Re: Planning Application EG/69/18/HH 86 Elm Grove Barnham PO22 0HE

Single Story Extension and Various Alterations to Existing Property

As nearest neighbour I have queries to raise re above application.

PROPOSED GROUND FLOOR PLAN

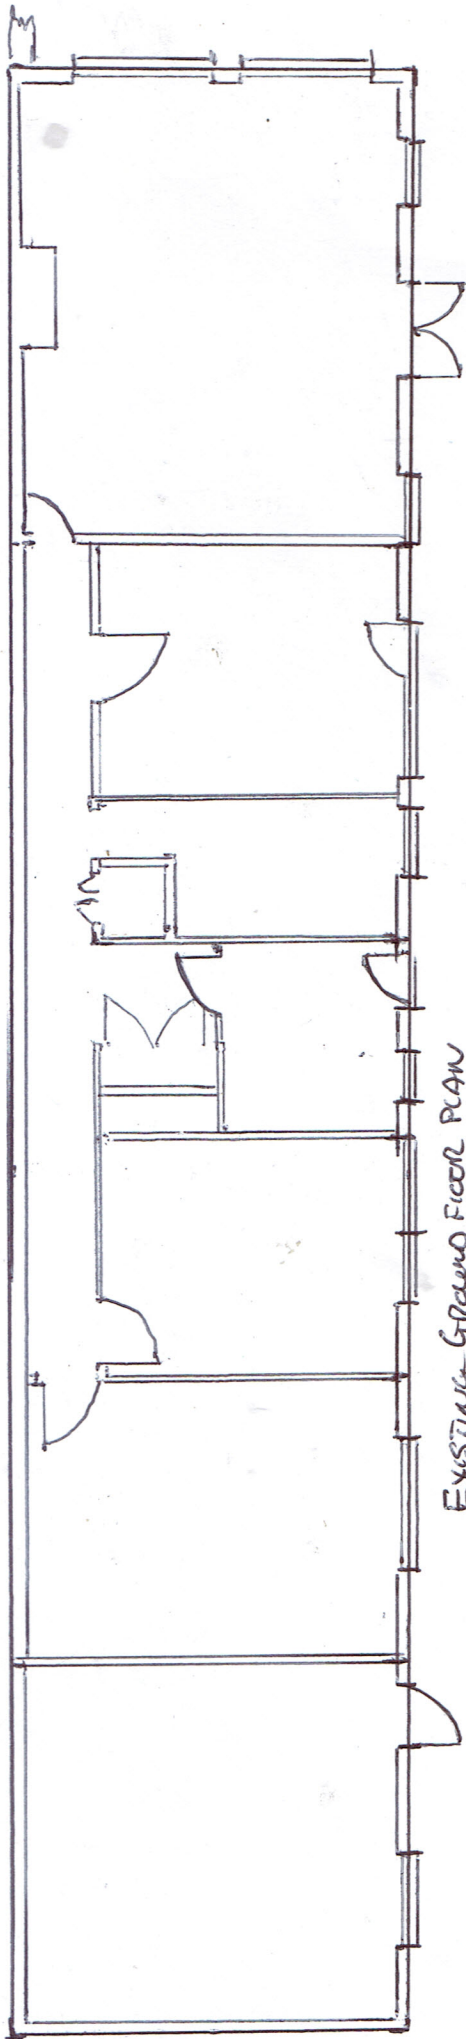
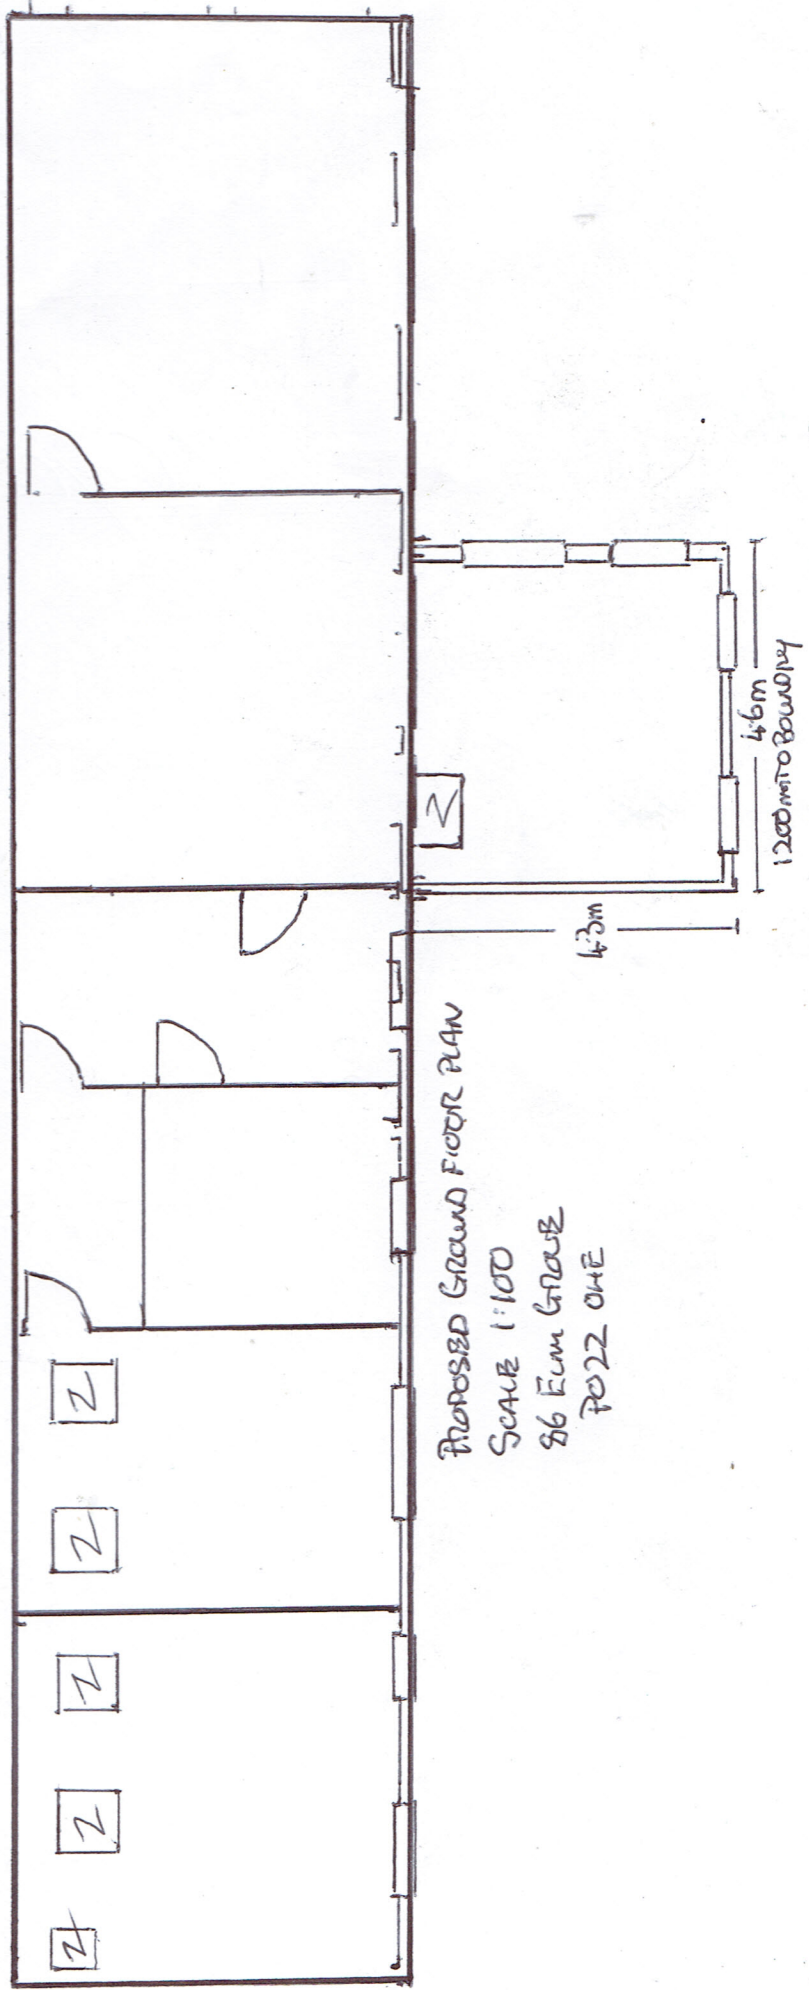
These include low paved paths and patio, raised lawn and beds plus a well, A further low wall with steps leads to the rear garden.

It is difficult to see how the plot can be 'evened out' to accommodate the building of any new structure across such a mixed site.

The lower areas have a history of flooding.

Digging new foundations and adding new building can only decrease the areas where surface water can drain away adequately without increasing future flood risk.

Soakaway – New Extension

Will this be a new soakaway or making use of an existing one? Again, a question of drainage.

Difficult to judge but light into my kitchen is already affected by very wide tall bush adjacent to my kitchen door close to where new extension is planned.
